FILE NO. 210426

TITLE Nakamura Residence  
Garage Addition  
Lateral Load Analysis

4245 90th Ave SE  
Mercer Island, WA

PREPARED BY Tom Wolfe, PE

NEW ROOF TRUSS NEXT TO EXISTING WALL DETAIL  
SCALE: NTS

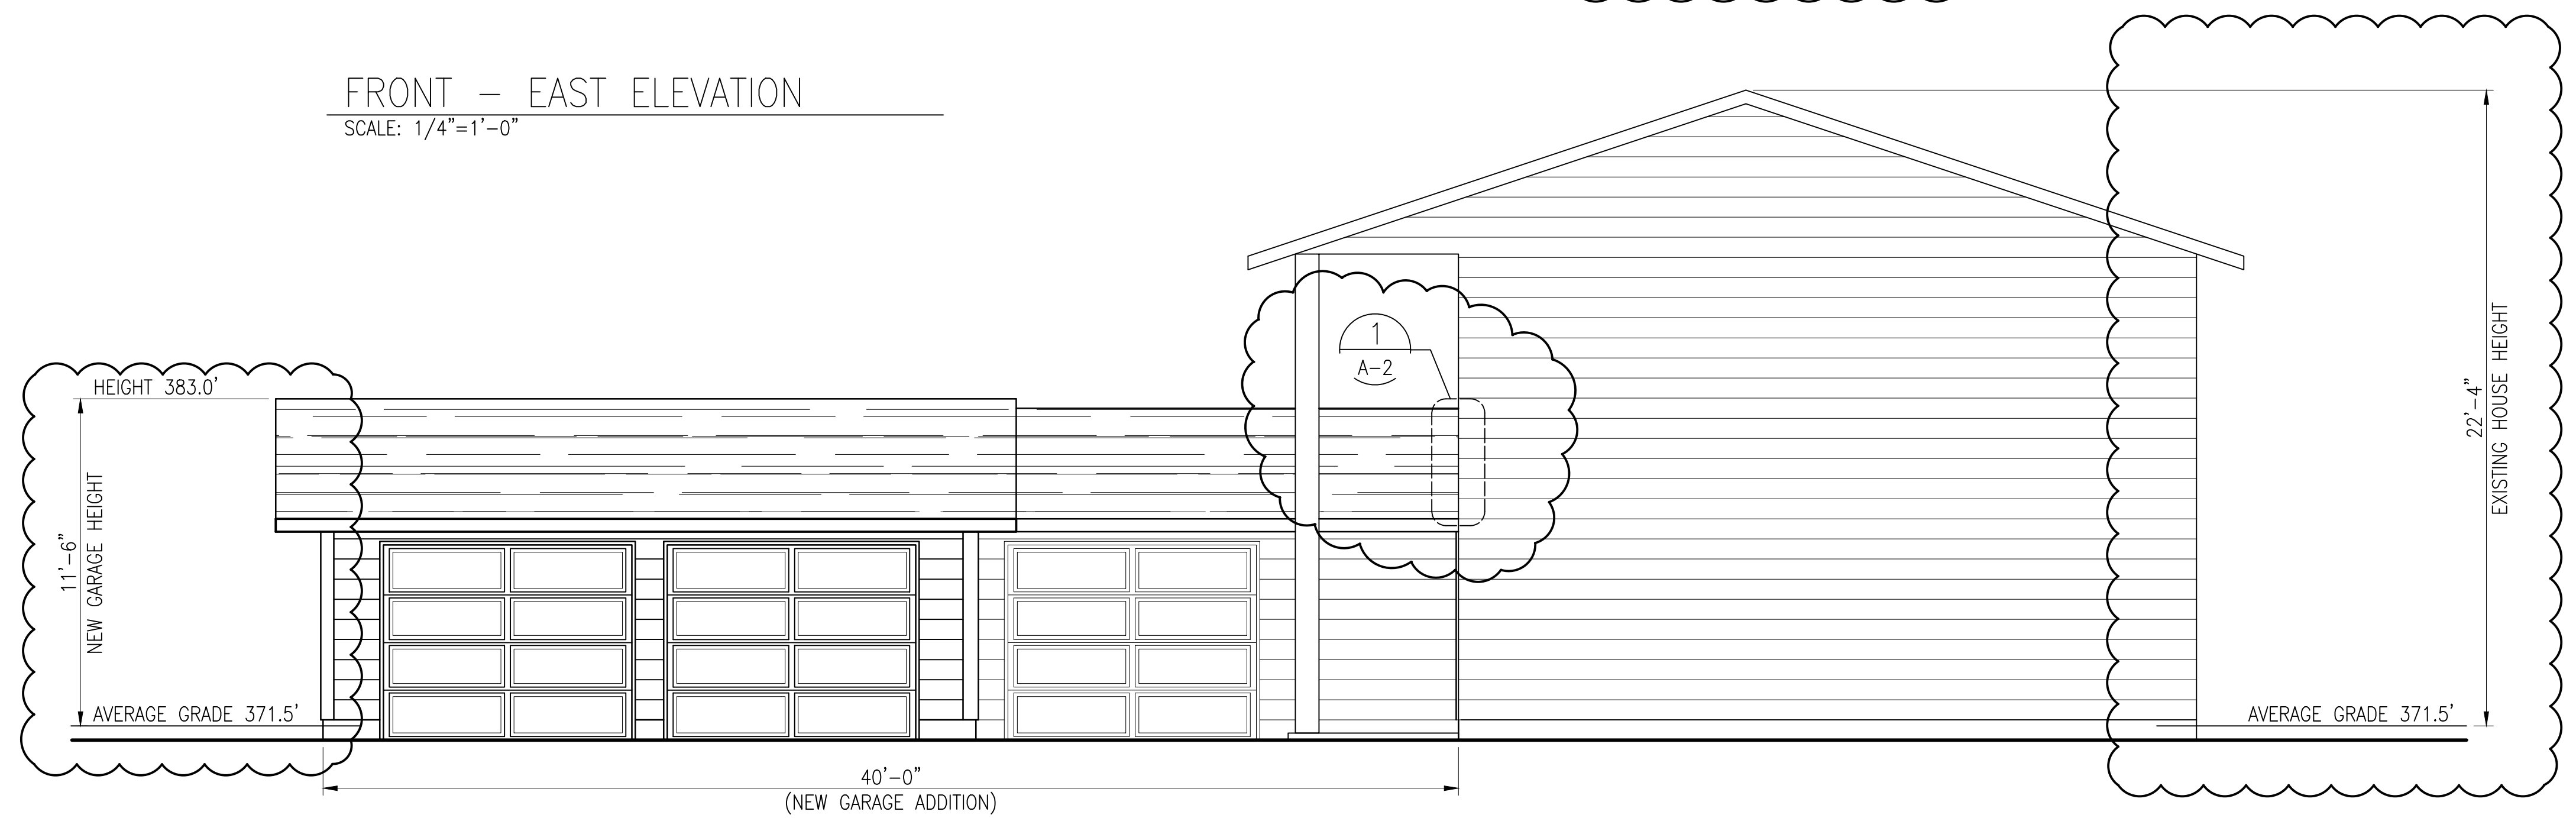
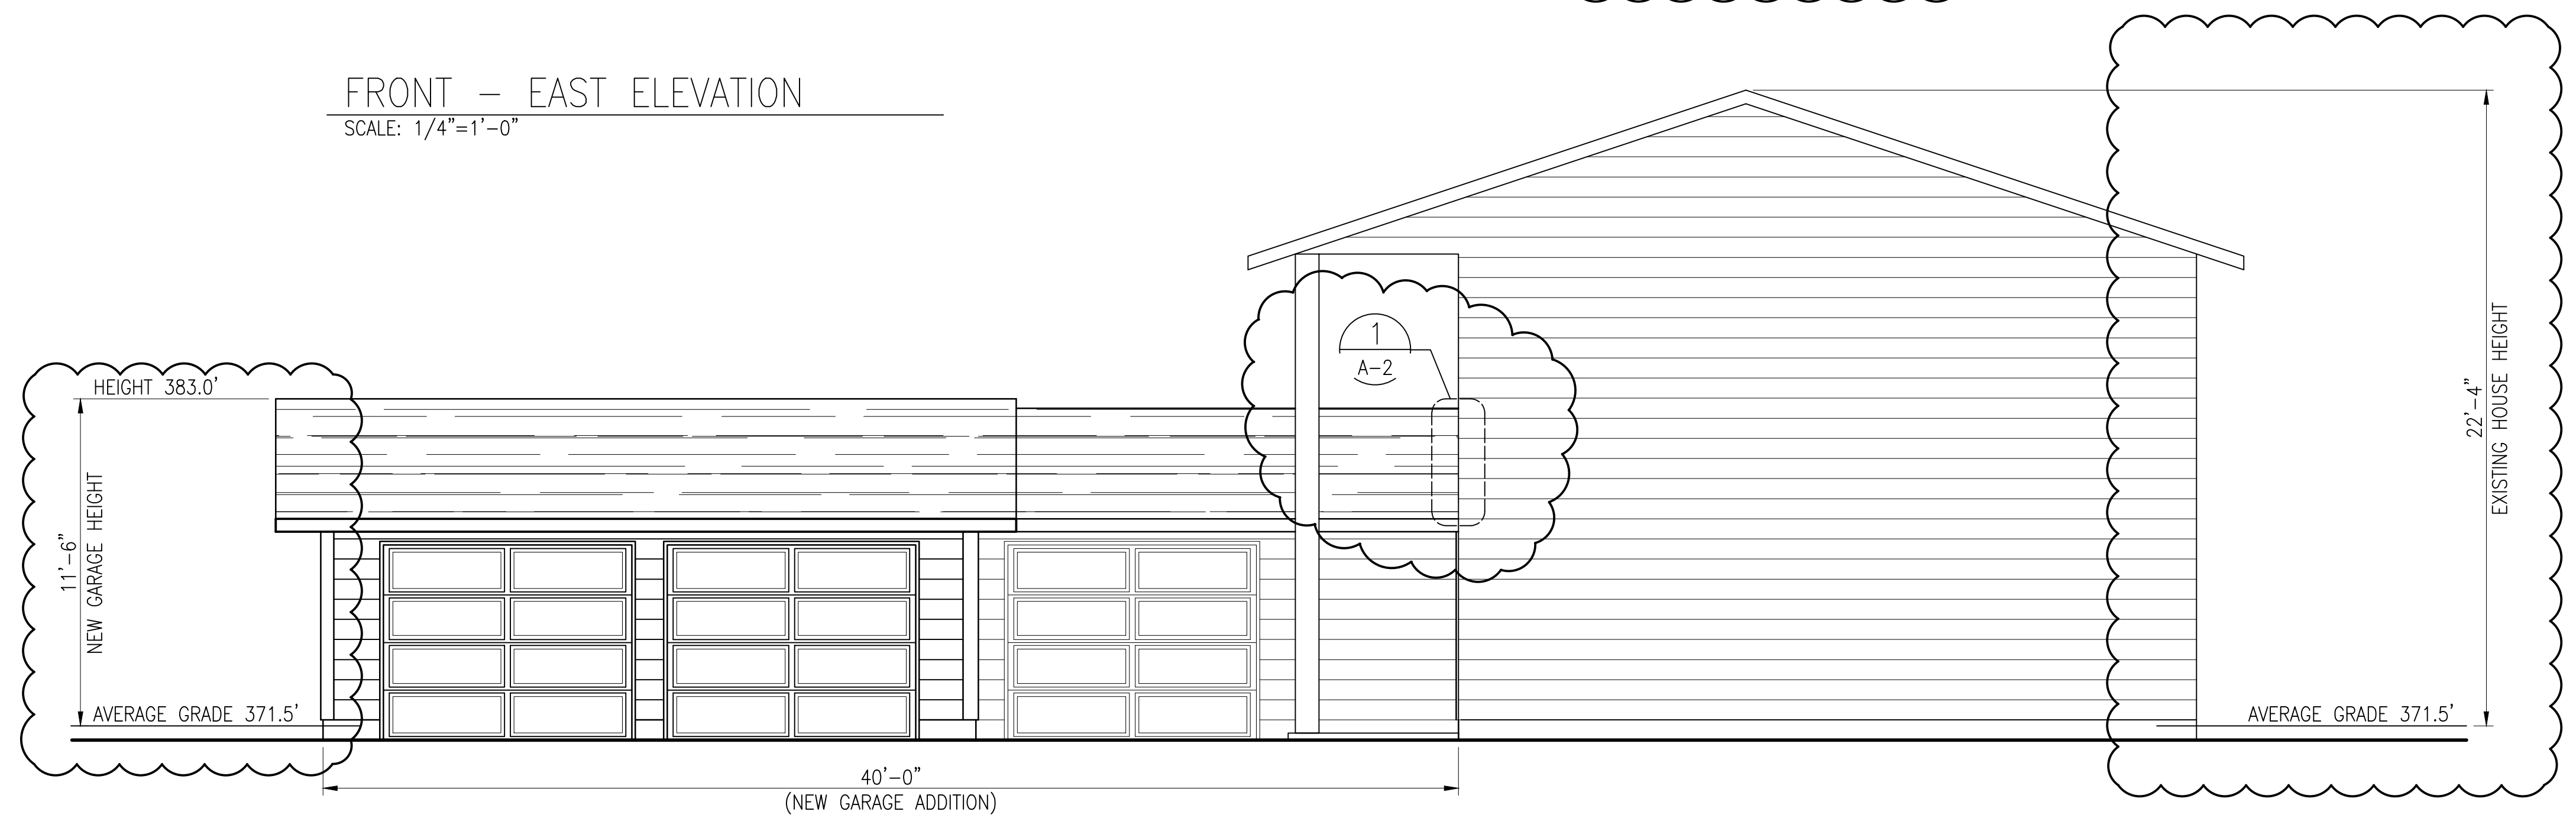
- Provide a detail where the new roof meets existing structure. Provide load path to LFRS
  - Detail has been provided based on load magnitudes in the following analysis
- Verify that tributary load from calculated lateral forces can be resolved to existing structure.
  - the analysis approach for this was described above and is further demonstrated in the analysis on the following pages
- Provide detail showing how portions of the structure are interconnected in accordance with ASCE 12.1.3, SDPWS Section 4.1.4, ASCE 7-10 Section 12.10.1
  - See following analysis and sketches provided
- Wind load has been evaluated for a basic wind speed of 110 mph
- Lateral design for new garage is provided:
  - includes a detail for the portal frames at garage doors
  - wind load includes a speed up factor,  $K_{zt}$ , of 1.6 per reviewer comment

See detail for connection of new roof truss/diaphragm to existing structure and LFRS
